WELWYN HATFIELD COUNCIL – DEVELOPMENT CONTROL
DELEGATED REPORT

APPLICATION No:	S6/2007/606/FP
------------------------	-----------------------

This application seeks permission to convert one of the existing attached garages to habitable accommodation. The garage currently has dimensions of approximately 2.3 metres in width by 5.1 metres in depth and would be utilised as a study. One additional window would be placed in the front elevation.

CONTRACT No.: 097/04054-02 **date:** 10/04/07

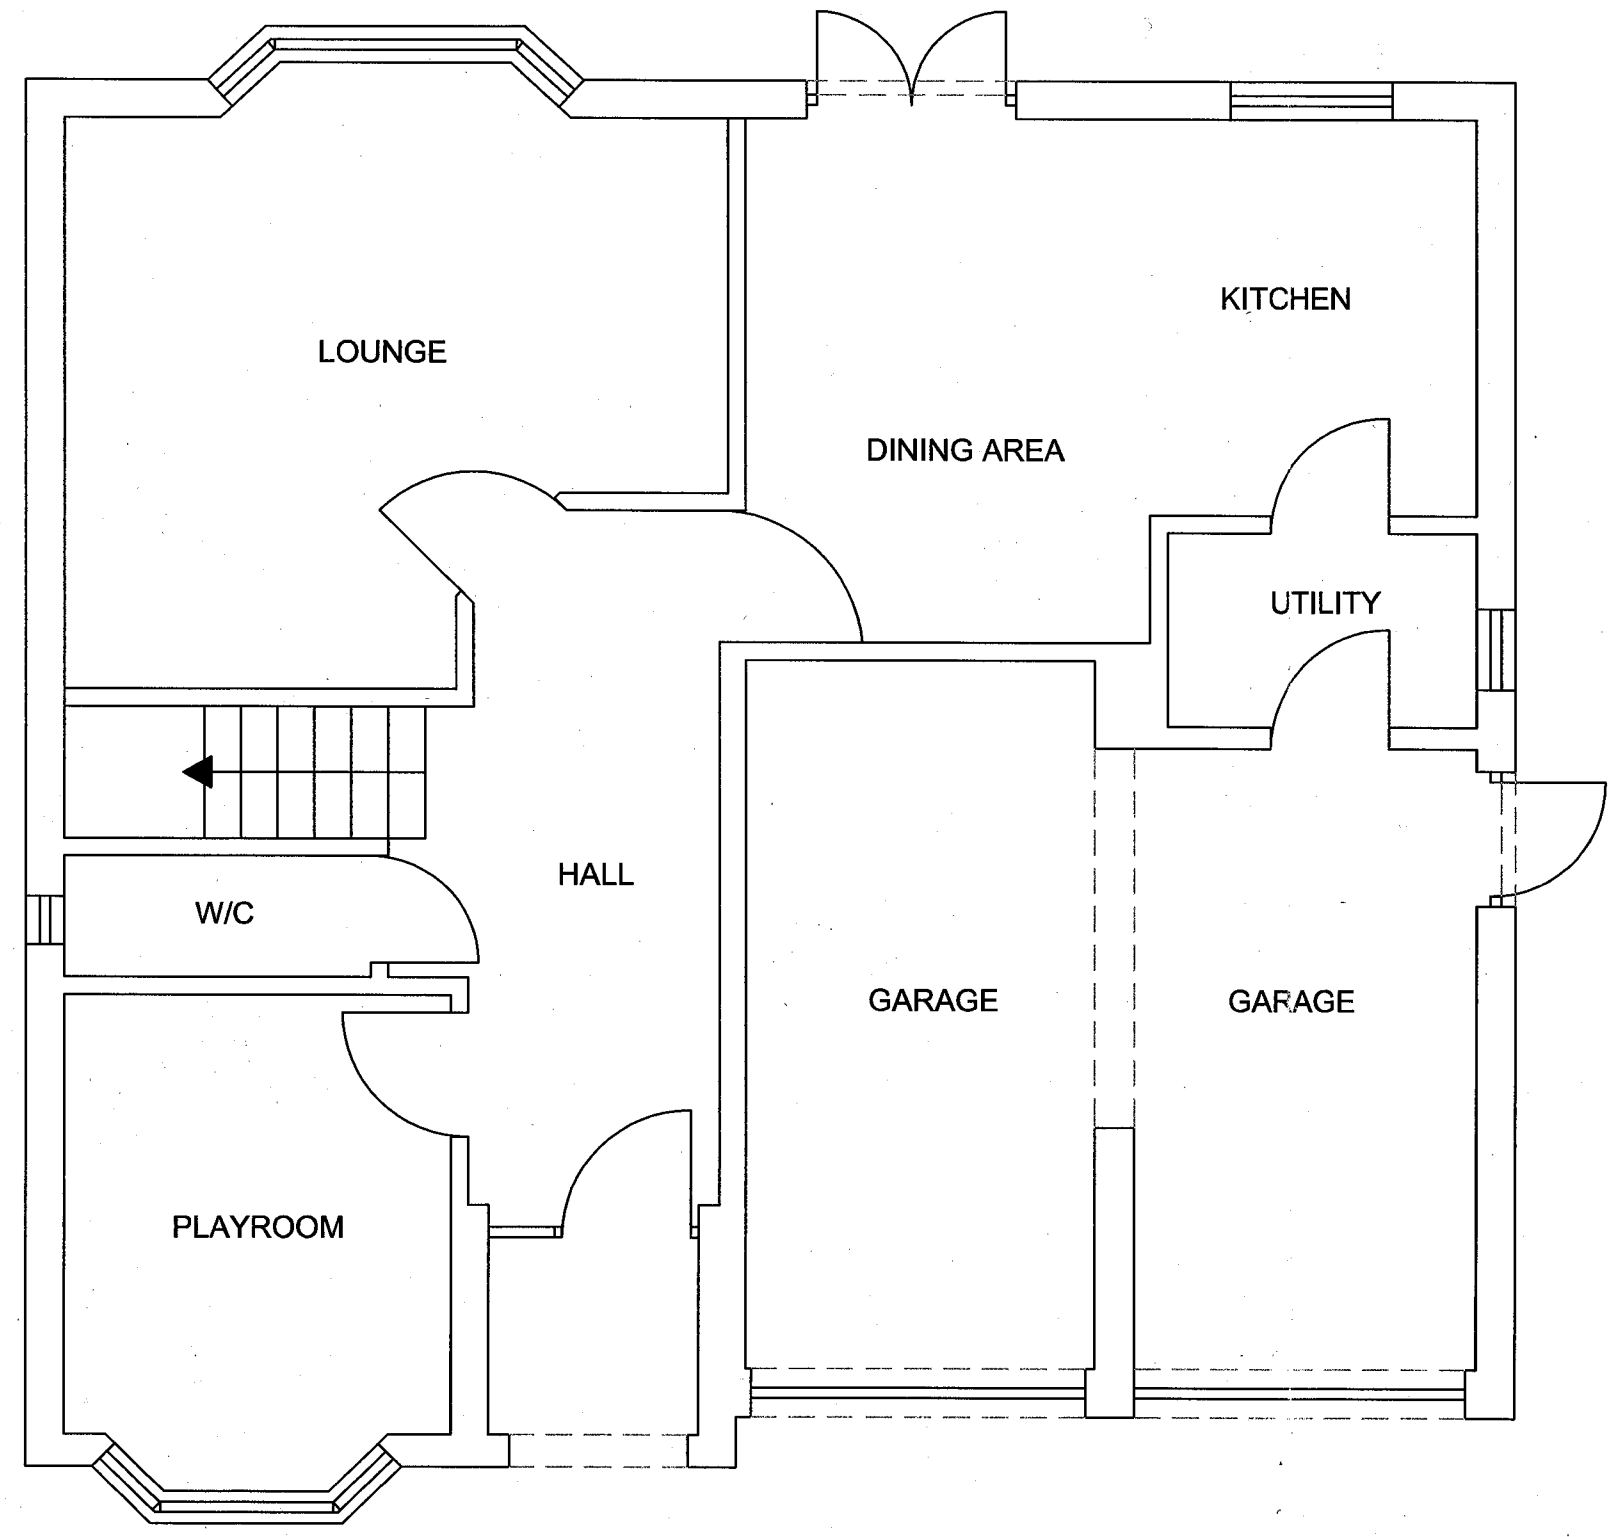
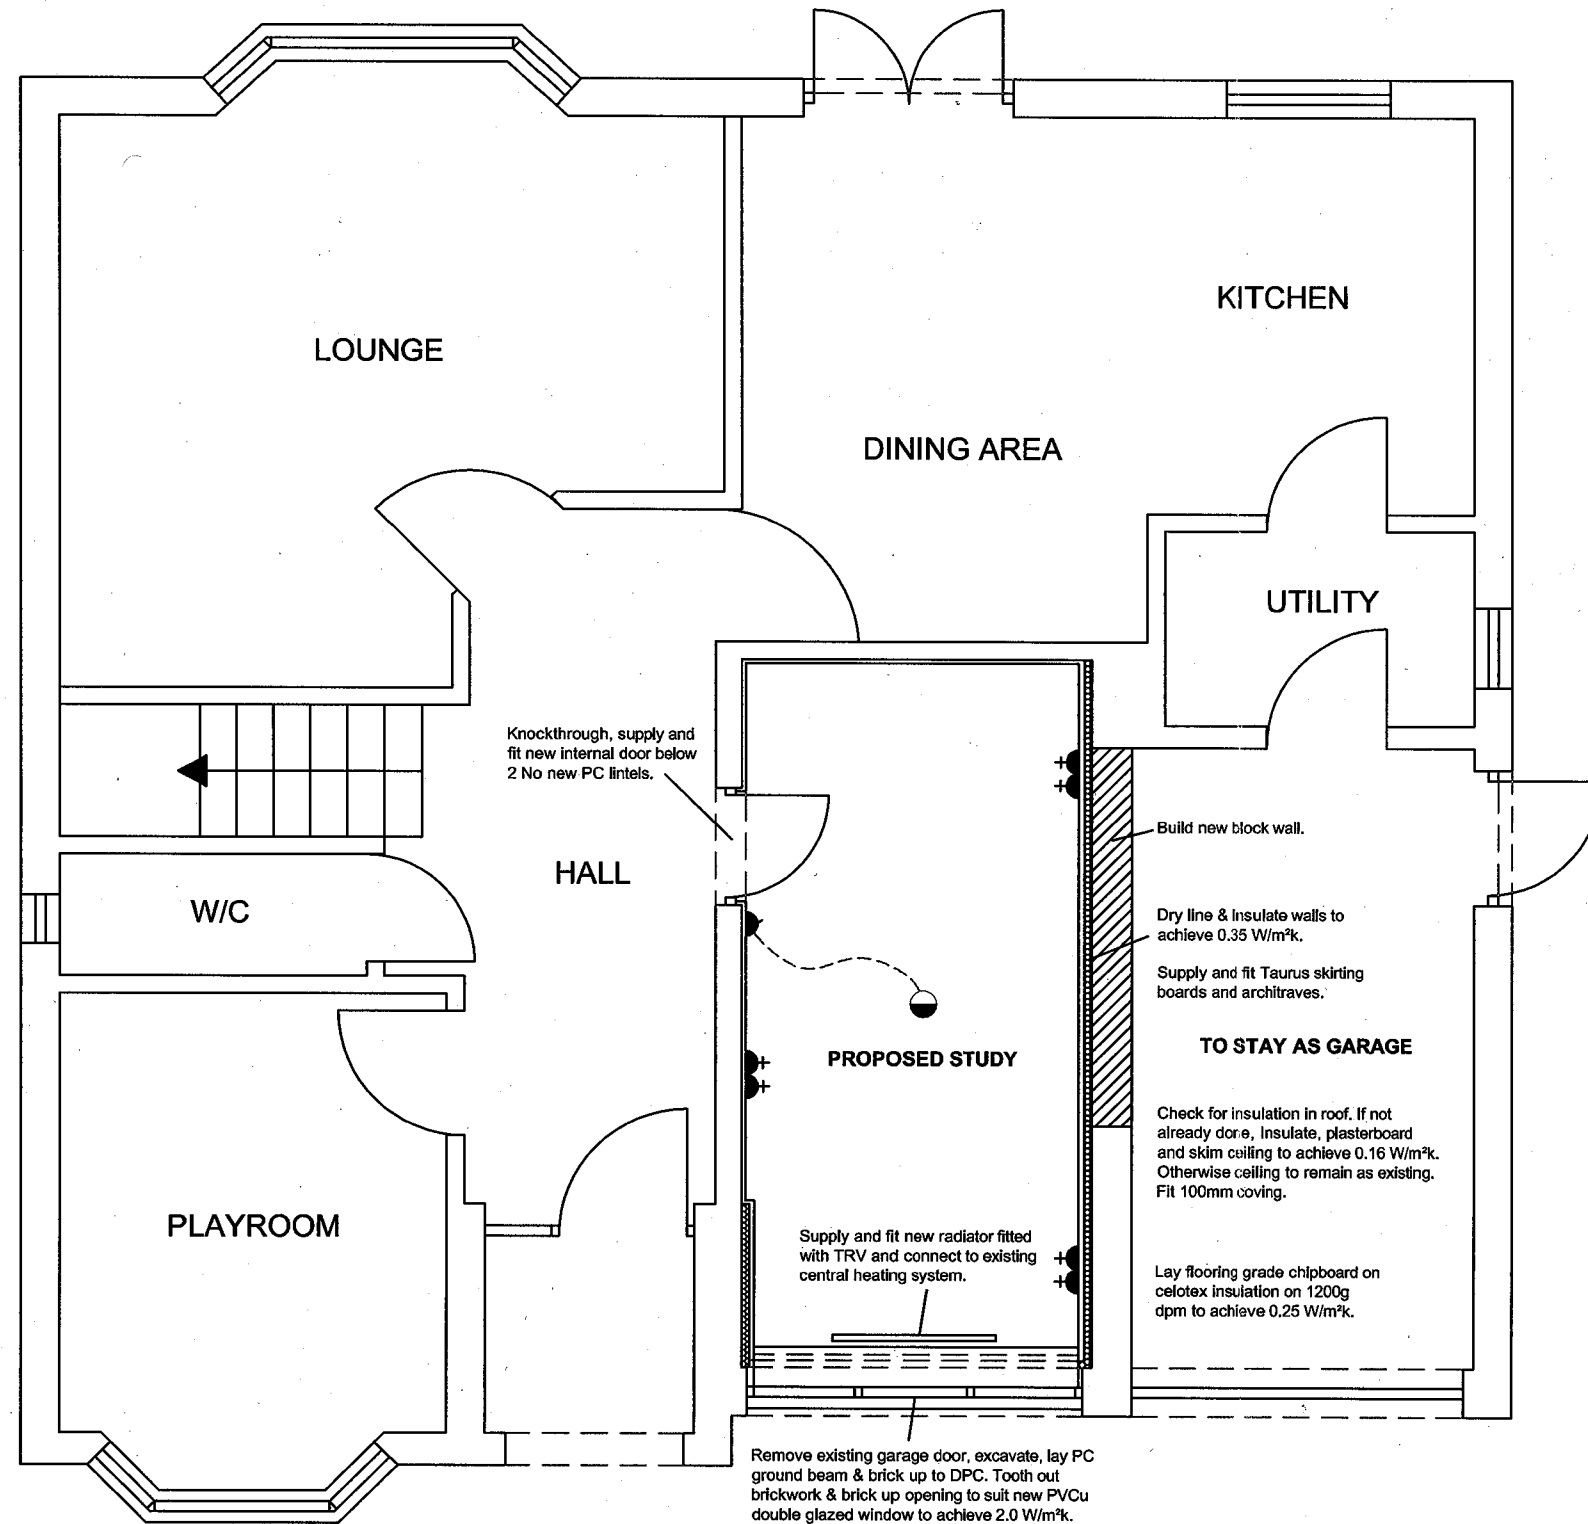
The conversion of the garage would not have a detrimental impact on the street scene as the external appearance of the dwelling would not be altered other than the addition of one further window in the front elevation at ground floor level. The window would be symmetrical to those within this front elevation and as such would be sympathetic to the design of the property. It is therefore considered that the visual impact would not be detrimental to the area and would respect and relate to the existing dwelling and street scene. Consequently, the proposals comply with Policy D1 and D2 of the Welwyn Hatfield District Plan and Section 5.2i of the Supplementary Design Guidance.

The conversion of the garage to habitable accommodation would not harm the amenity of the occupiers at 17 or 13 Great Braitch Lane in regards to loss of light or privacy as the building would remain unaltered other than one window, which would be placed in the front elevation and therefore have views towards the street scene. Consequently, the garage conversion complies with the material contained within Section 5 of the Supplementary Design Guidance.

The garage conversion would be constructed of materials to match the existing building, which therefore adheres to Section 5.2iv of the Supplementary Design Guidance.
